From: [Rory Toomey](#)
To: [Phillip Rossington](#); [Georgia McKenzie](#)
Cc: [Troy Uleman](#); [Andrew Harvey](#); [Zoe Gleeson](#); [Vijay Prabhu](#); [Guy Pinkerton](#)
Subject: RE: Alexandria Health Centre - Design Integrity Panel Endorsement
Date: Friday, 7 June 2024 10:35:44 AM
Attachments: [image002.png](#)
[image003.png](#)
[image004.png](#)
[image005.png](#)
[image006.png](#)

RE: Alexandria Health Centre DIP Review RTS

DESIGN INTEGRITY PANEL ENDORSEMENT - ALEXANDRIA HEALTH CENTRE

Drawing Title
**GROUND FLOOR
GENERAL
ARRANGEMENT
PLAN**

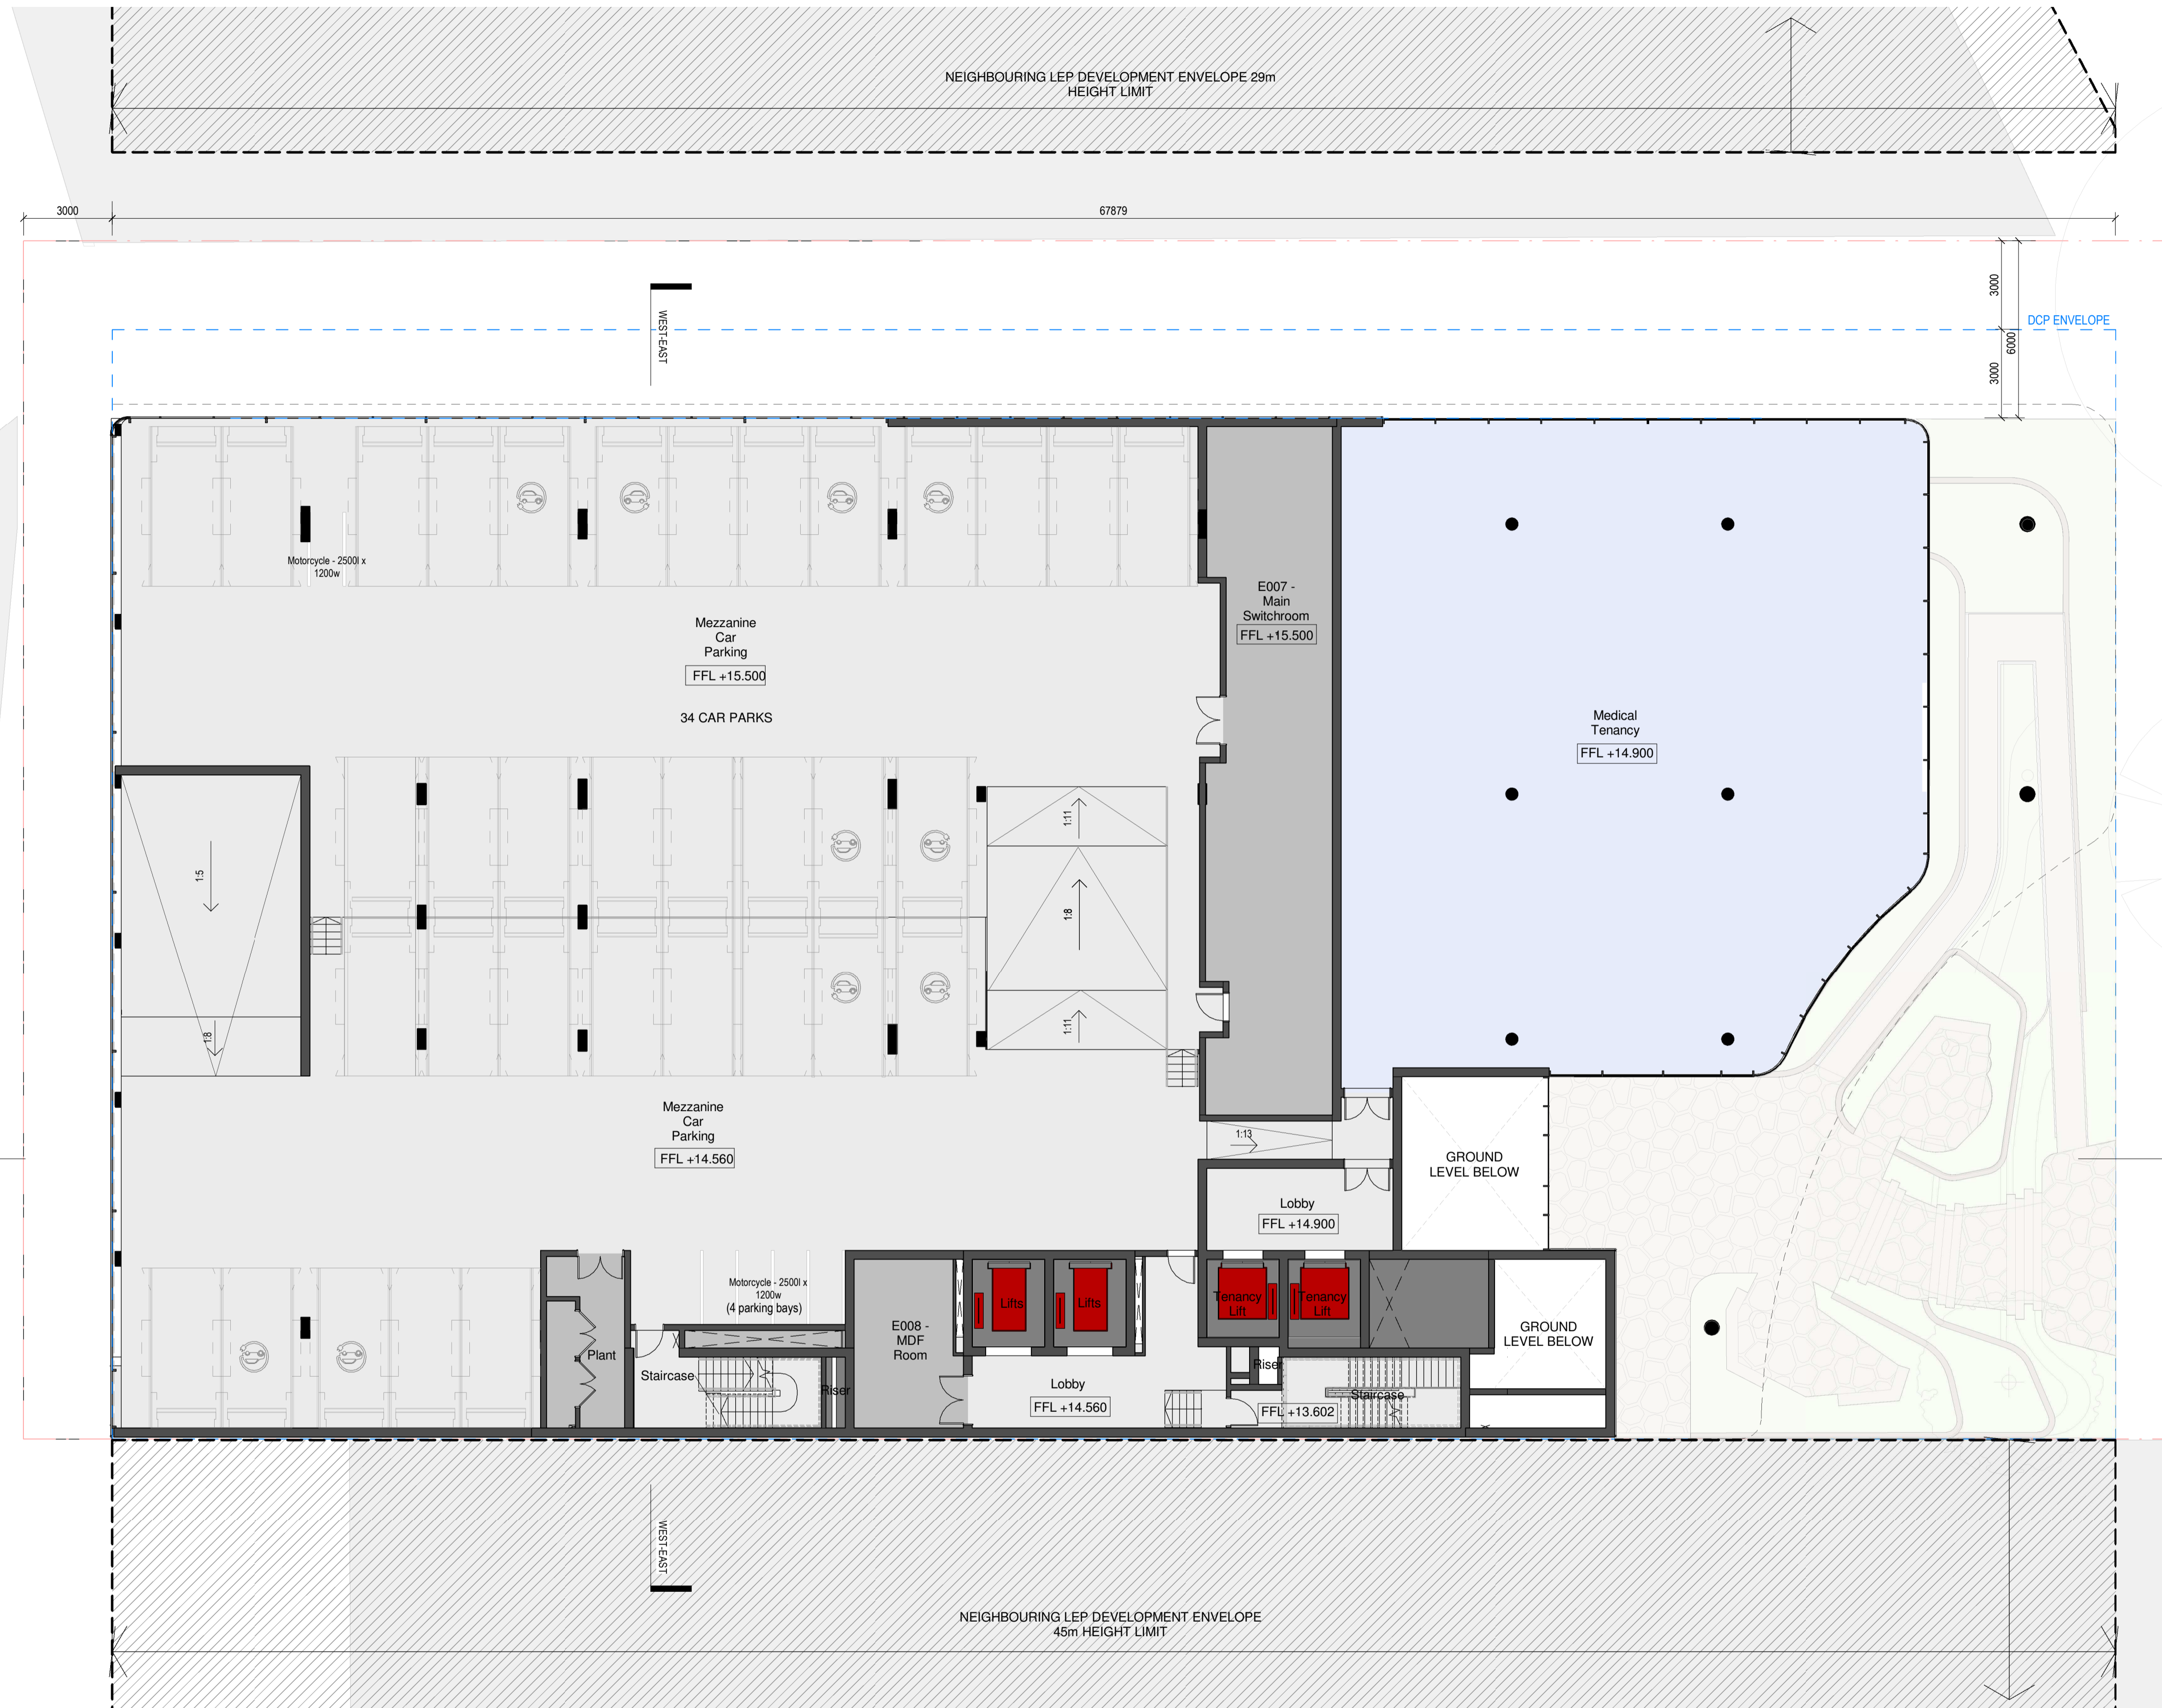
- Number and allocation of parking spaces
- Function, location and treatment of grease arrestor
- Legibility, safety and wayfinding for patient drop off space

1. Allocation of staff and visitor car parking spaces in car park for clarity.
2. Relocation of in-ground grease arrestor from the northern landscaped area to western laneway.
3. Position of the drop off area on the ground floor shifted to the north, in accordance with traffic advice
4. Relocation of the boom gate within the car park, in response to City of Sydney feedback. Installation of a second boom gate on the mezzanine level.
5. Widening the ramp to the mezzanine to allow safer circulation.
